Re: Williams Glass/Emery Worldwide

RE: DRAINAGE PLAN FOR WILLIAMS GLASS/EMERY WORLDWIDE
(N-15/D1A4) RECEIVED MARCH 27, 1990

RE: REVISED DRAINAGE PLAN FOR WILLIAMS GLASS/EMERY WORLDWIDE
(N-15/D1A4) REVISION DATED APRIL 16, 1990

RE: ENGINEER'S CERTIFICATION FOR TRACT 2B, AIRPORT TECHNICAL
CENTER WILLIAMS GLASS/EMERY WORLDWIDE (N-15/D1A4)
CERTIFICATION STATEMENT DATED APRIL 11, 1991

**GRADING & DRAINAGE**

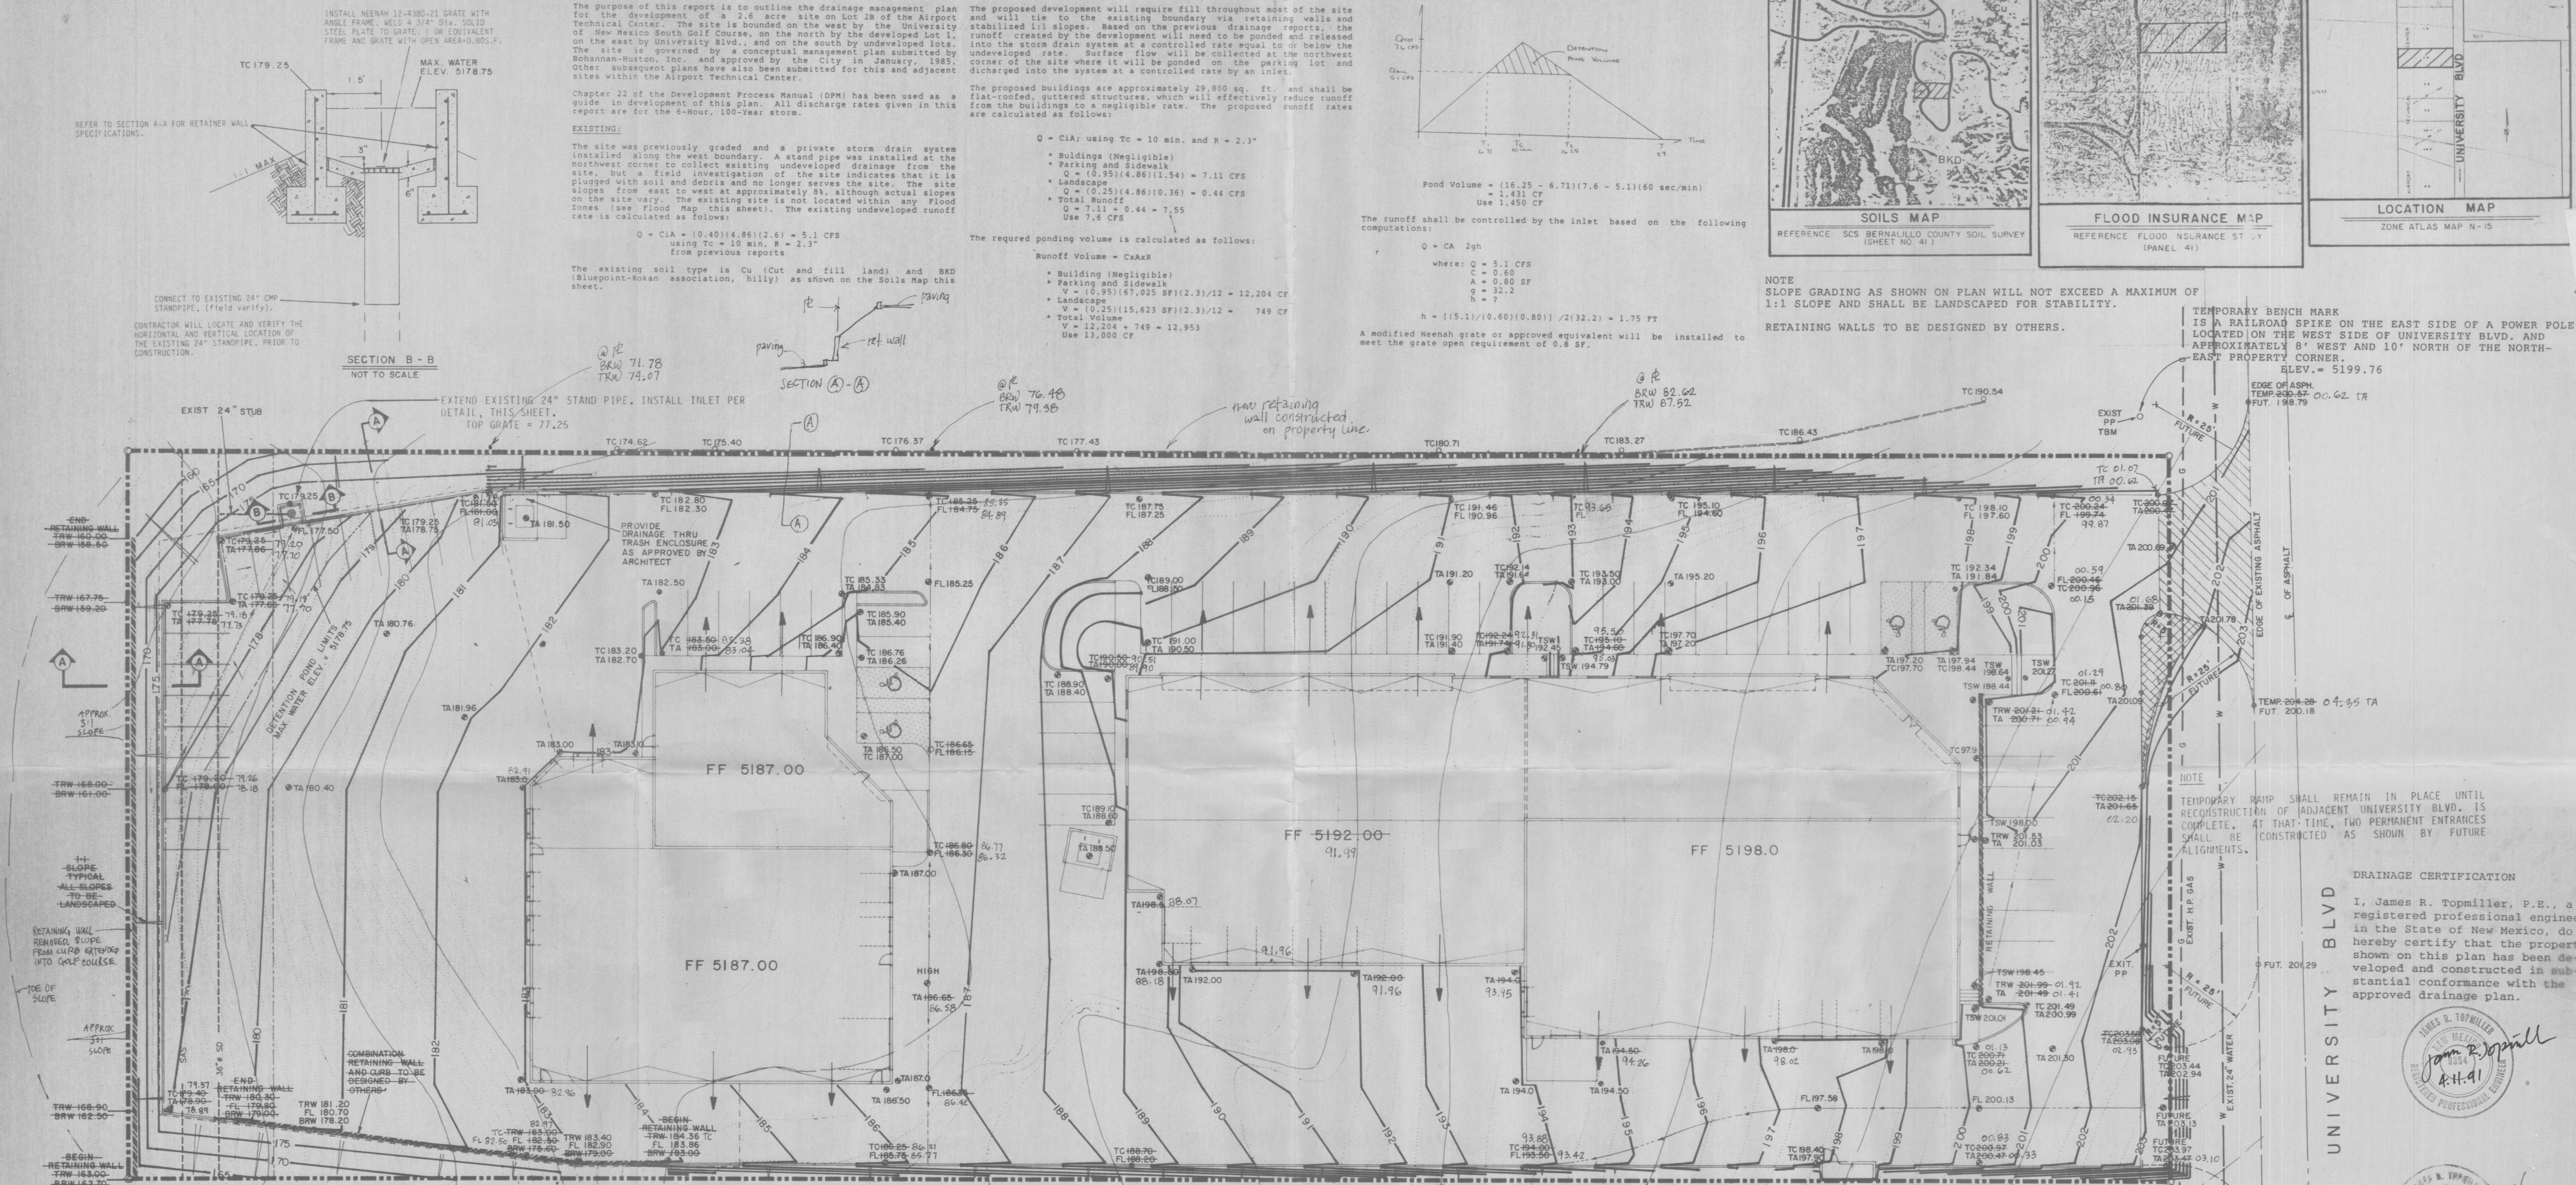
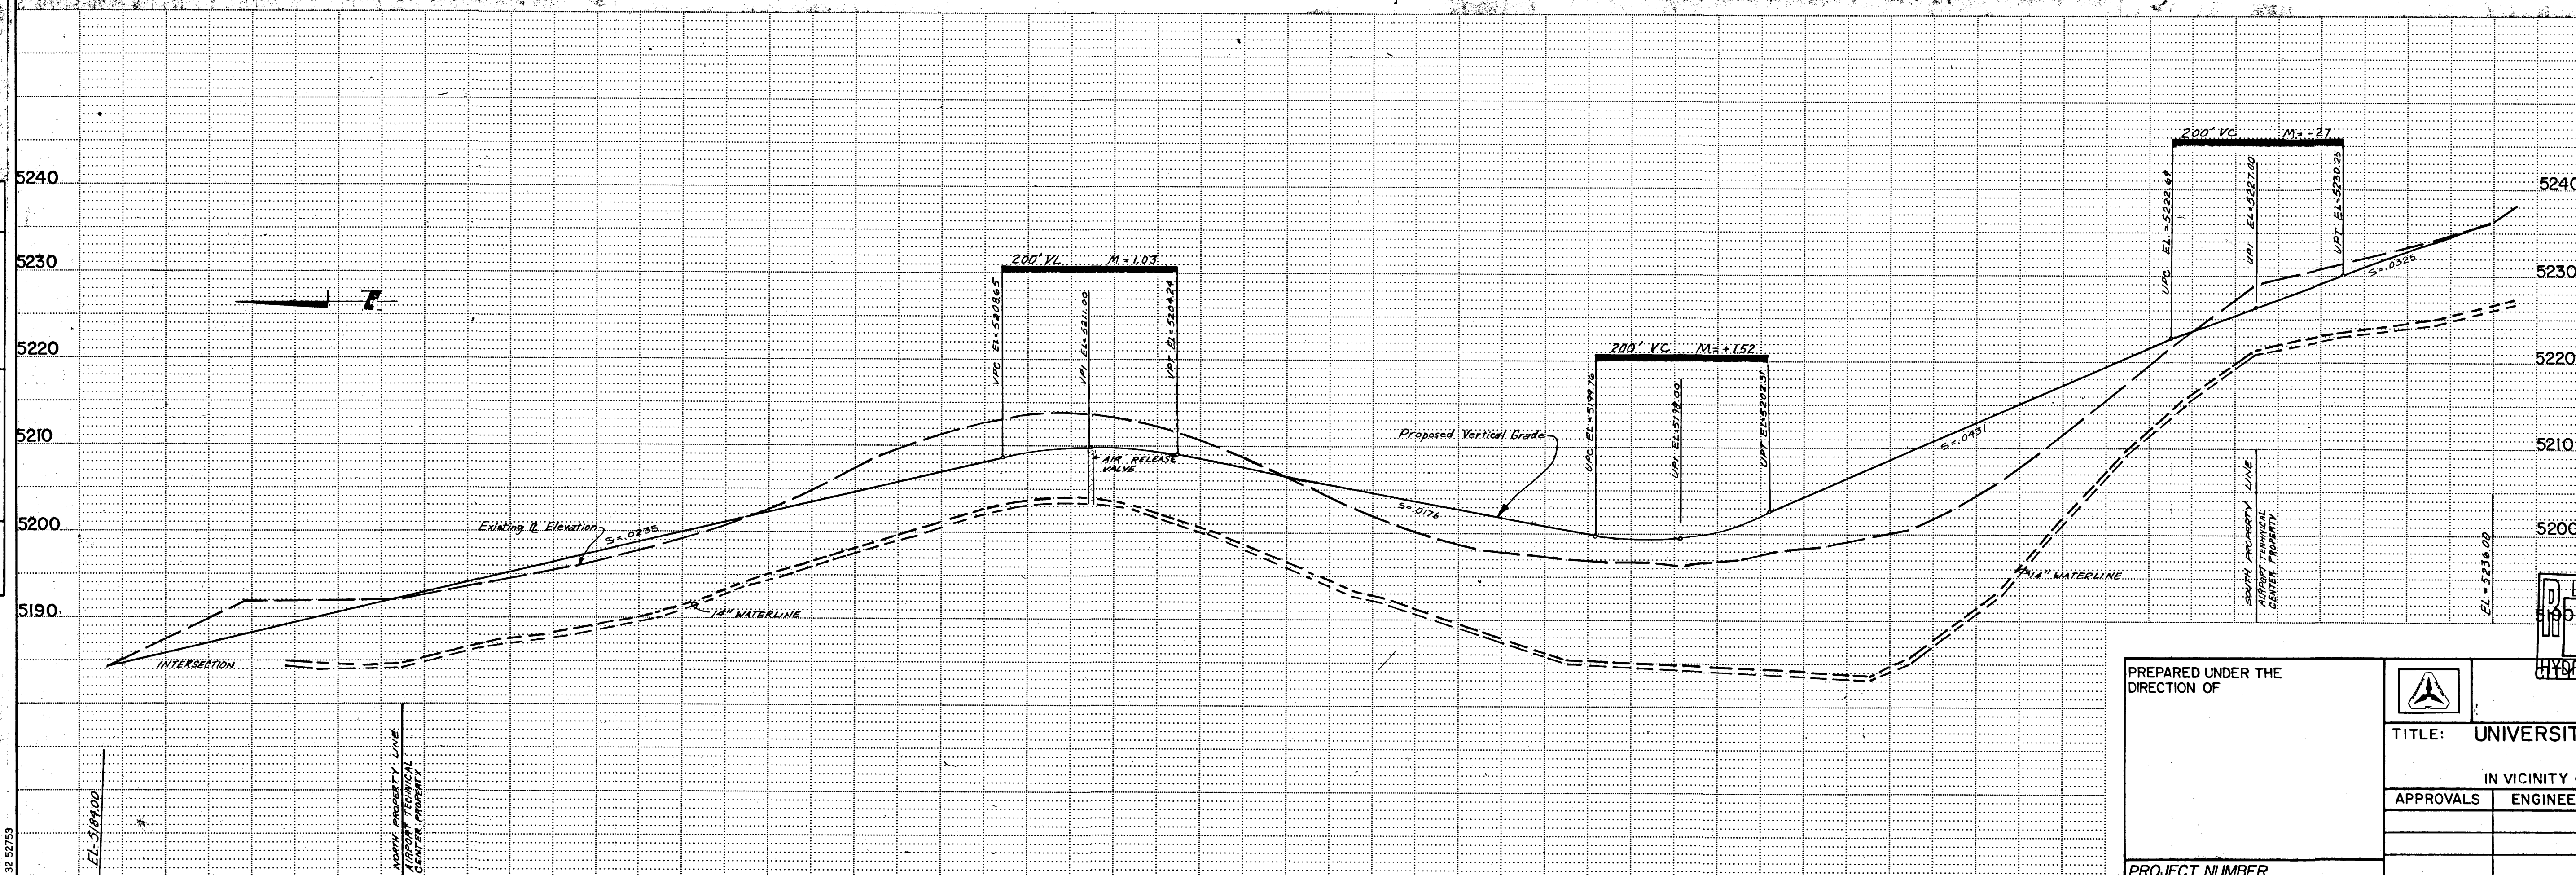
1. What ACS monument was used to set the T.B.M.? Location, description and elevation.
2. Please provide a copy of the approved street grades for University Boulevard.
3. Location and direction of roof drains.
4. Emergency spillway location, what will happen if the proposed grate inlet is plugged?

Also, the north slope which is designed for a 1:1 slope, must be stabilized at the time of Certification.
